Recommendation Report for Planning Permission for Works or Extension to a Dwelling

REF NO: **AW/163/15/HH**

LOCATION: 1 The Dunes
 Aldwick Bay

PROPOSAL: 3 storey extension including moving living area to first floor level & 2 bedrooms
 with en-suite in the roof.

NEW NORTH ELEVATION

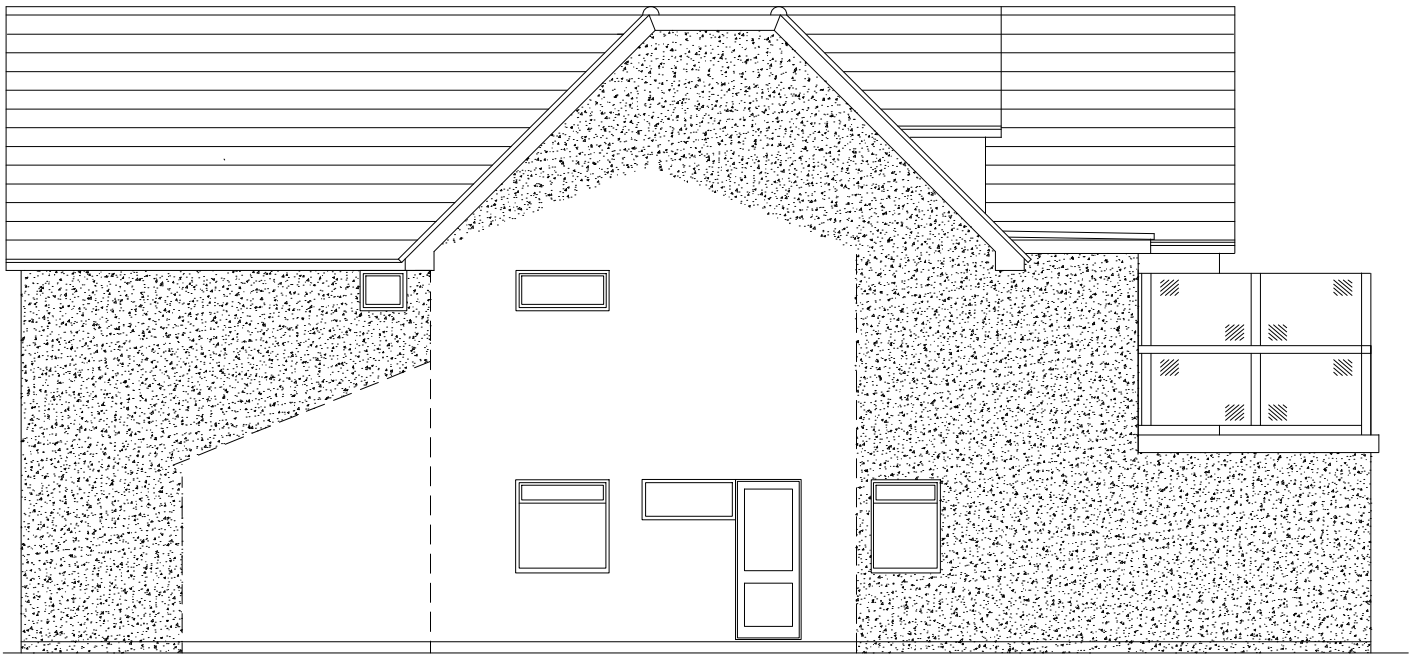
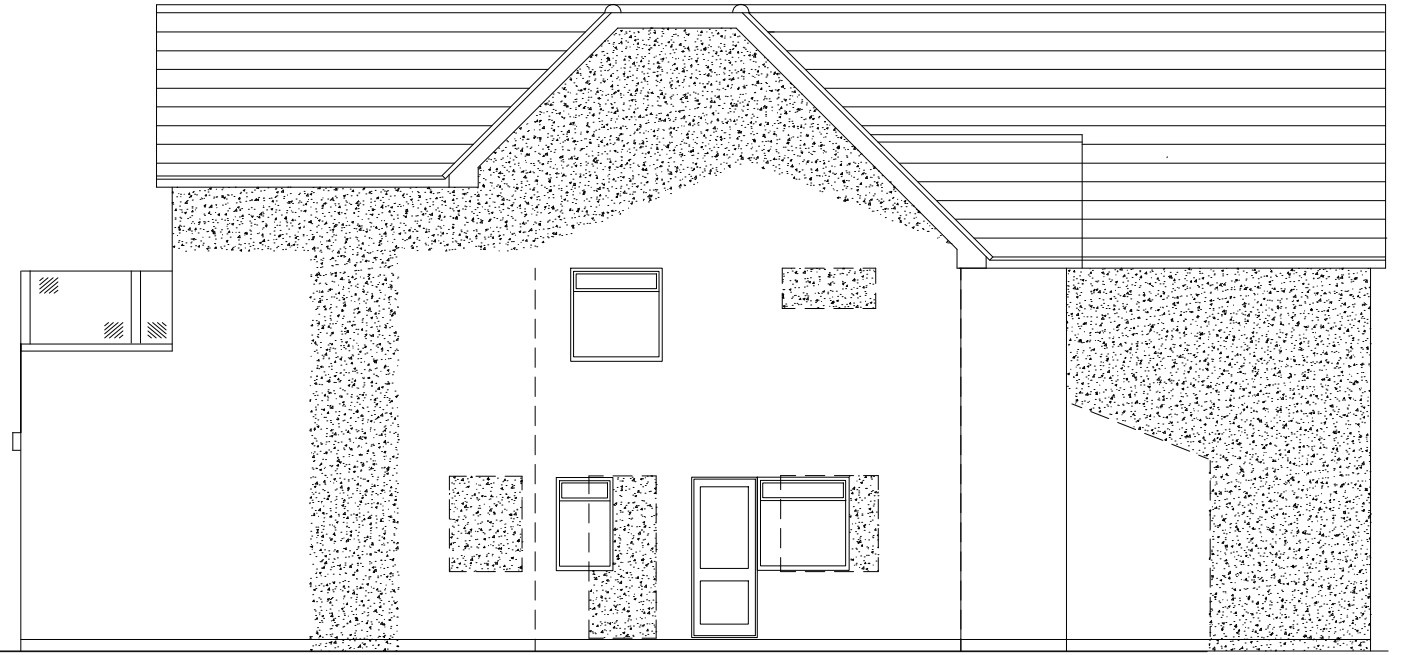
Other properties in Dunes have hipped roofs - proposals represent a 3 storey building out of character for the street and causing overshadowing.

Appearance of east and west elevations have not been given consideration.

Gable 30% wider and 2m higher.

Suggest hipped ends not gable.

The plans have been amended to show half hip roofs and the two storey garage element reduced to single storey with pitched roof.

SITE PLAN

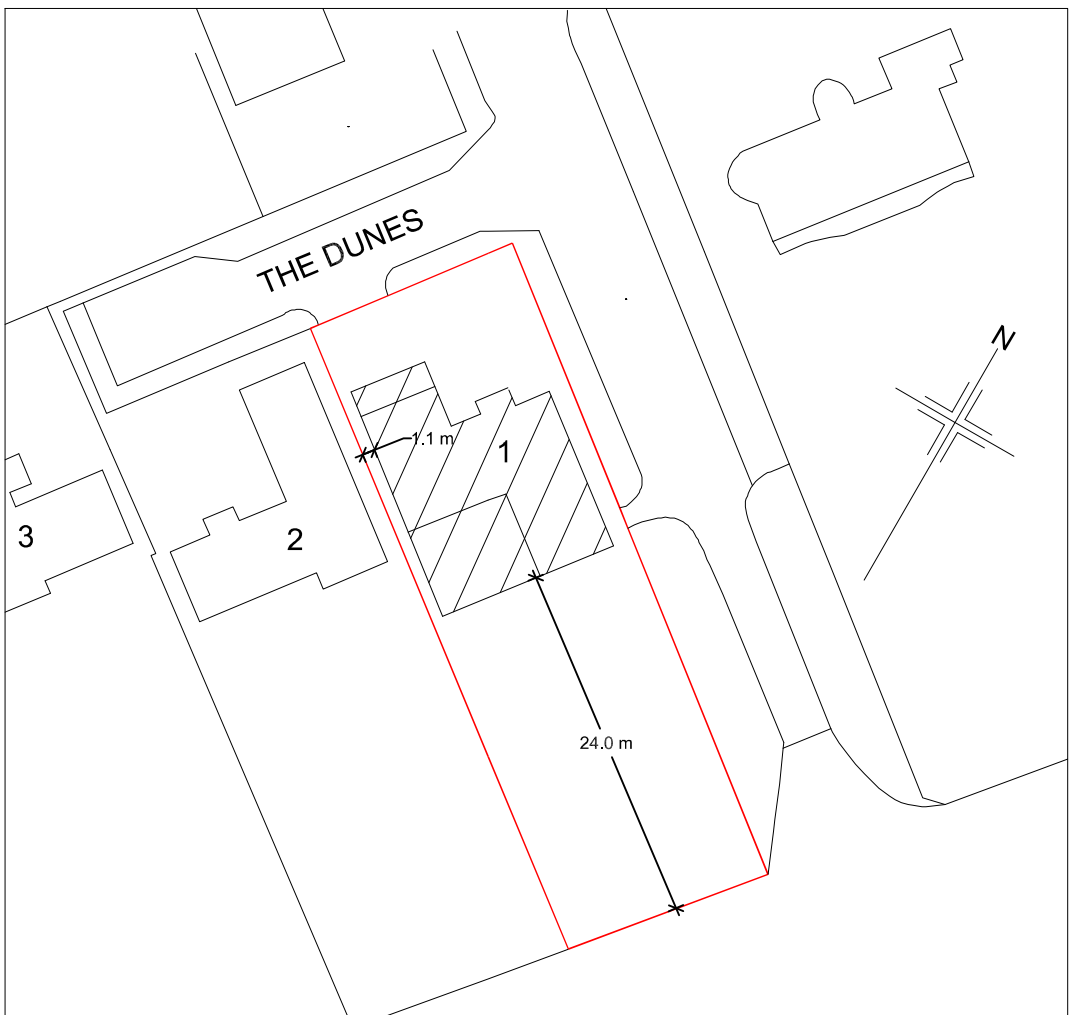
Site plans incorrect.

The plans have been amended to reflect the extended neighbouring property.
